CITY OF ALBUQUERQUE

September 27th, 2016

Re: Drainage Control Ordinance and NPDES CGP Violations for Erosion and Sediment Control and Cement Pollution – Village at Avalon

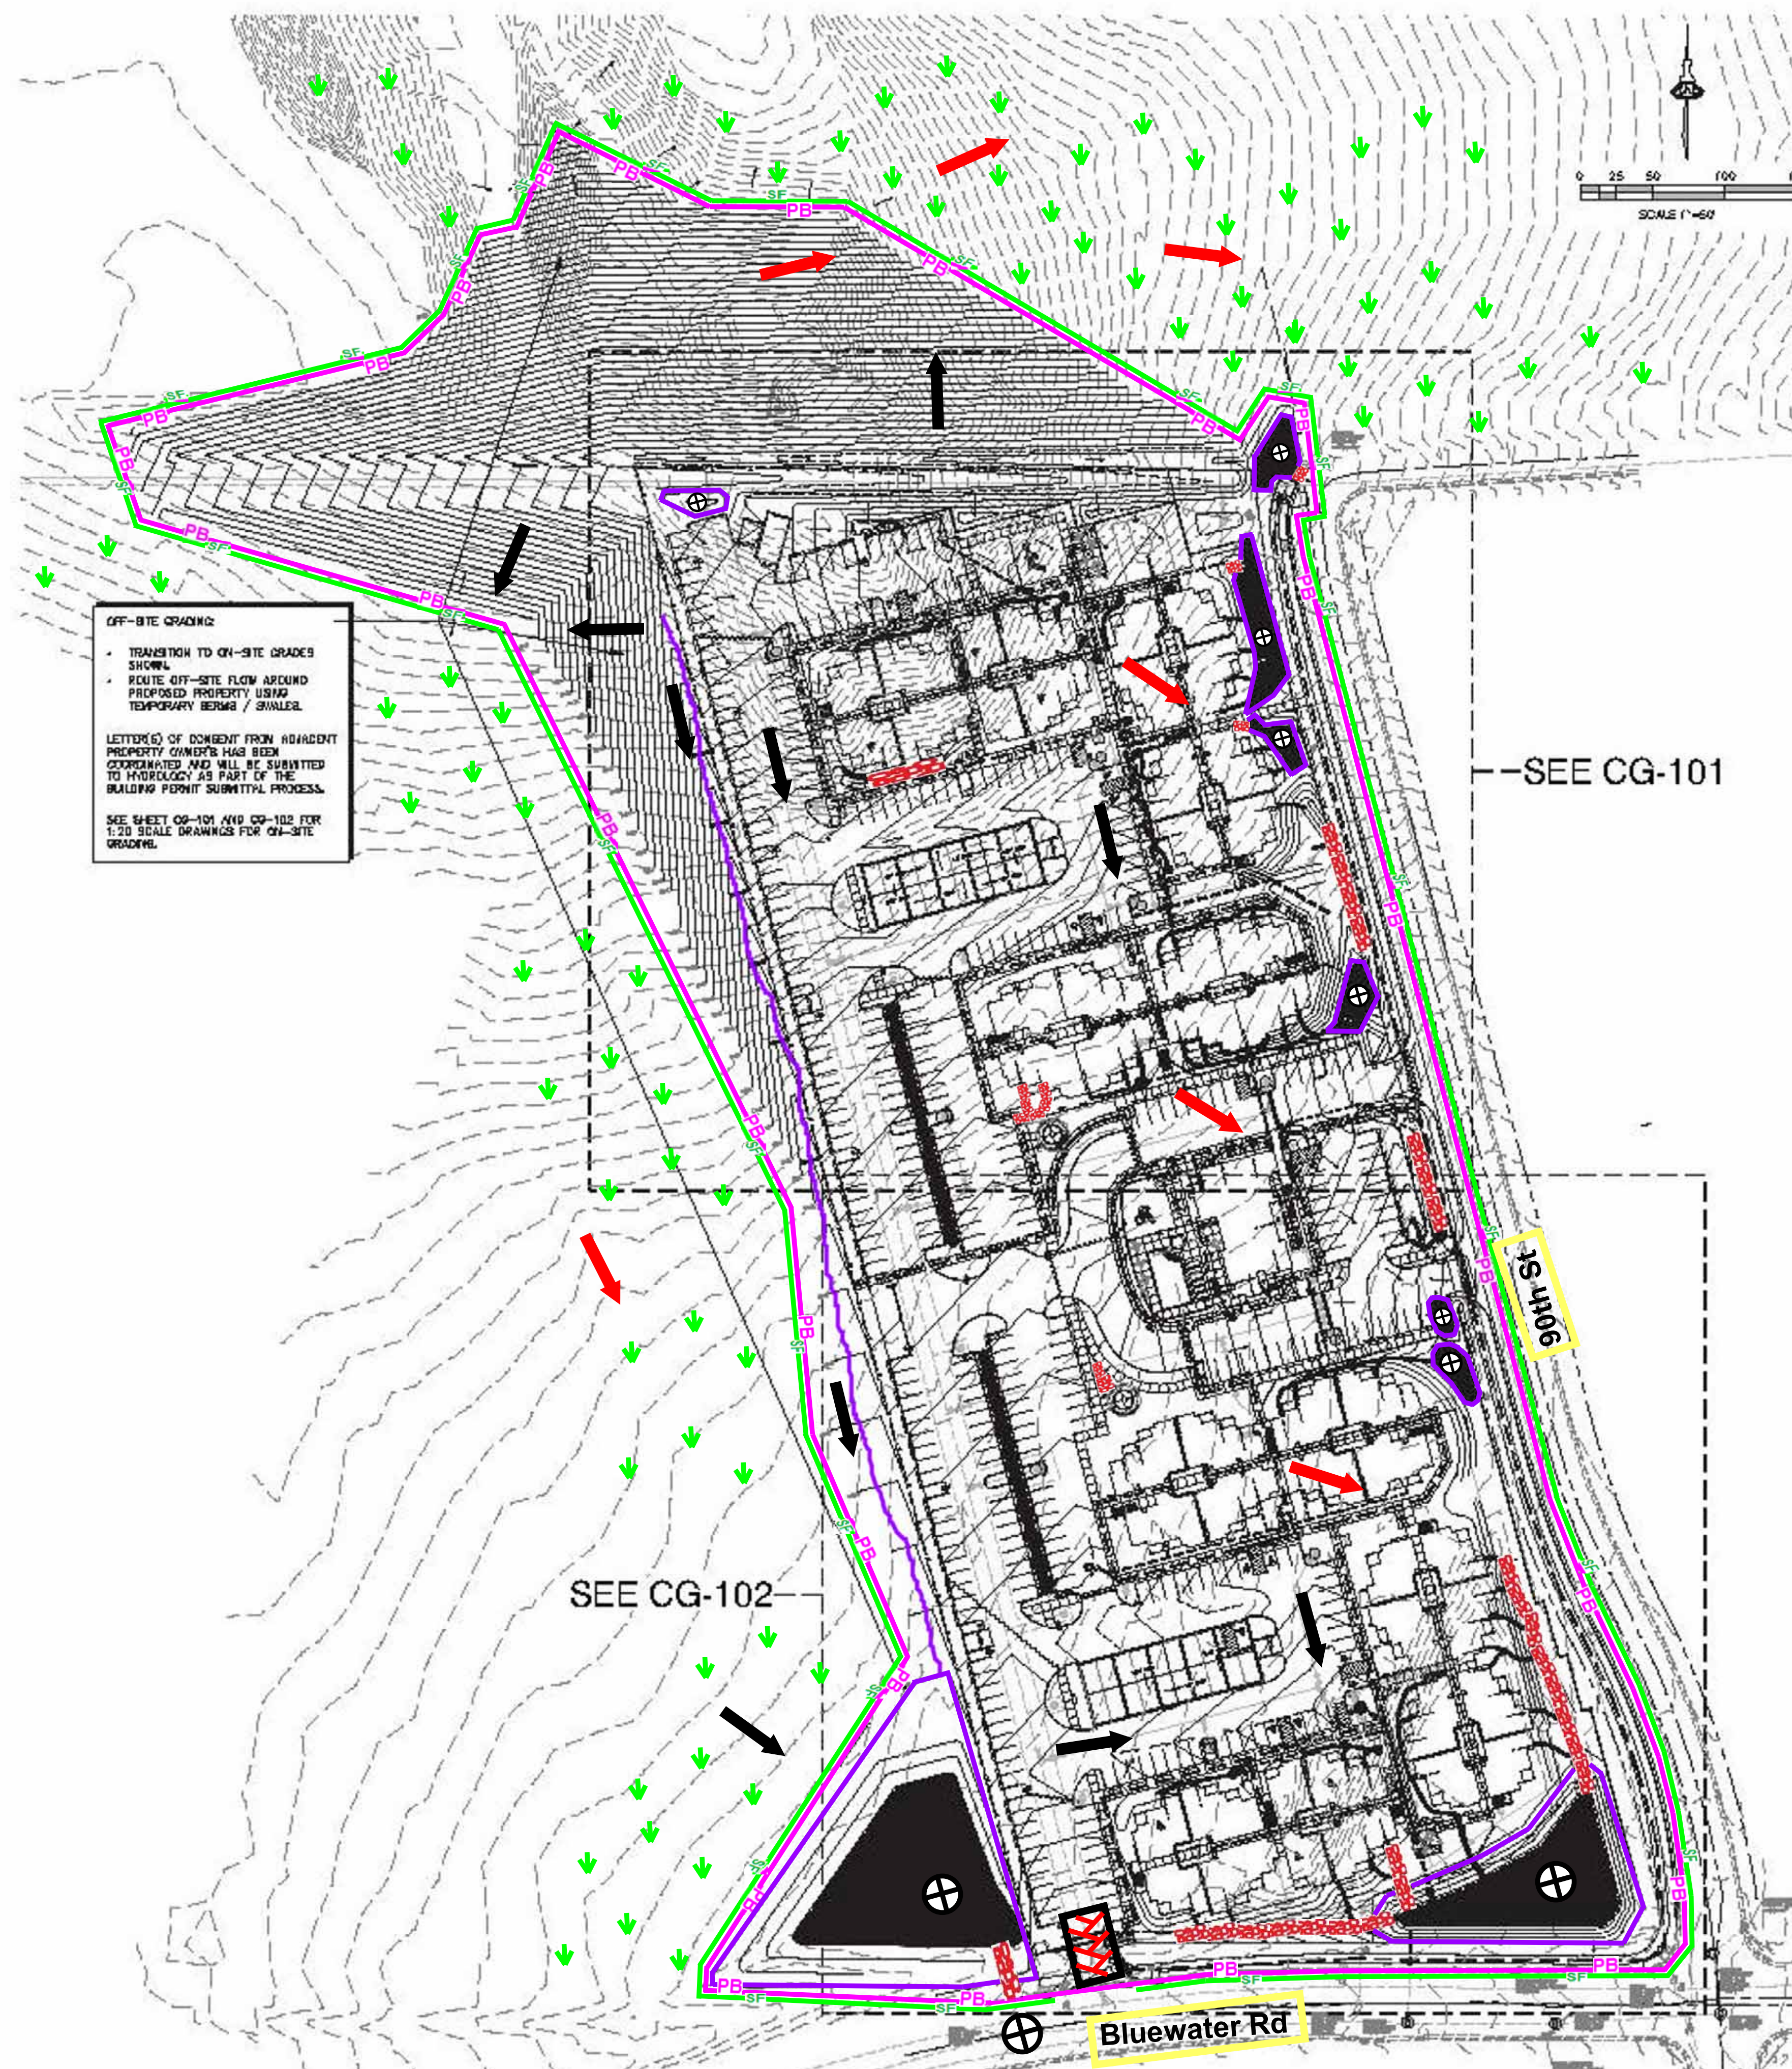
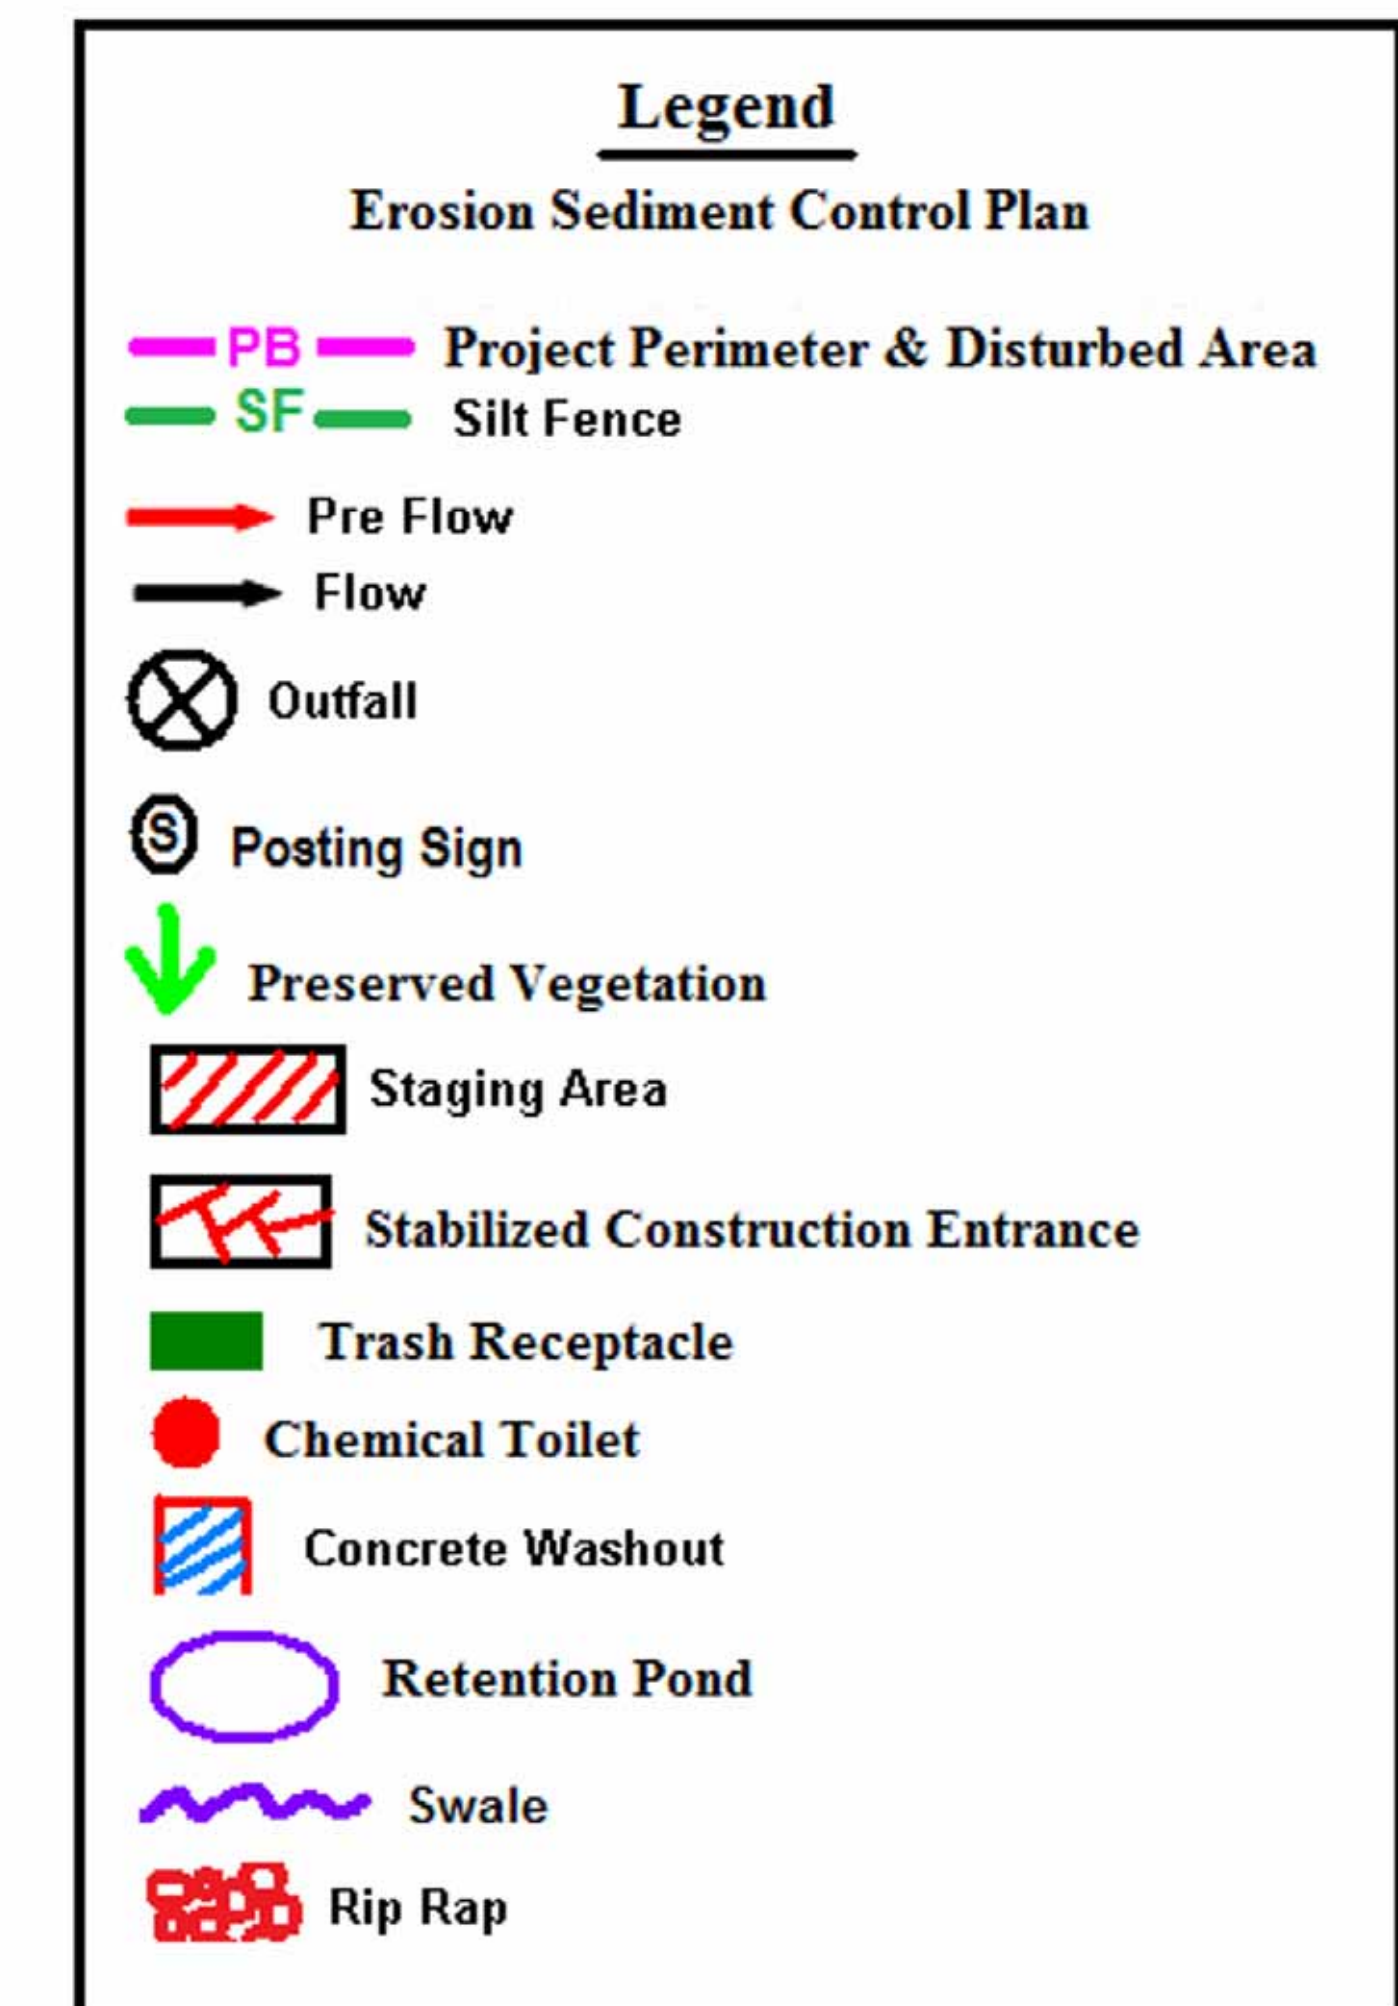
1. The stabilized entrance still needs maintenance. It looks the same.
2. The wash-out bin was full.
3. Sediment was observed in Bluewater Rd. and at the intersection of Bluewater Rd. and 90th St.
4. The silt fence from the entrance on 90th St. south to Bluewater Rd to the west project boundary on Bluewater Rd.: is not buried in some locations and, has holes/gaps in it. In one location it was tied-up away from the ground.
5. The site was dry. This is contributing to the sediment in Bluewater Rd

1. Maintain the stabilized entrance.
2. Replace/maintain the silt fence from the entrance on 90th St. south to Bluewater Rd to the west project boundary on Bluewater Rd.
3. Replace the full wash-out bin/ provide an acceptable location for cement (concrete/mortar/stucco) wash-out.
4. Remove sediment from Bluewater Rd and sediment in gutter at the intersection of Bluewater Rd. and 90th St.
5. The area between the wall and the project boundary from the entrance on 90th St. south to Bluewater Rd to the west project boundary on Bluewater Rd. should be kept wet enough to prevent windblown sediment.
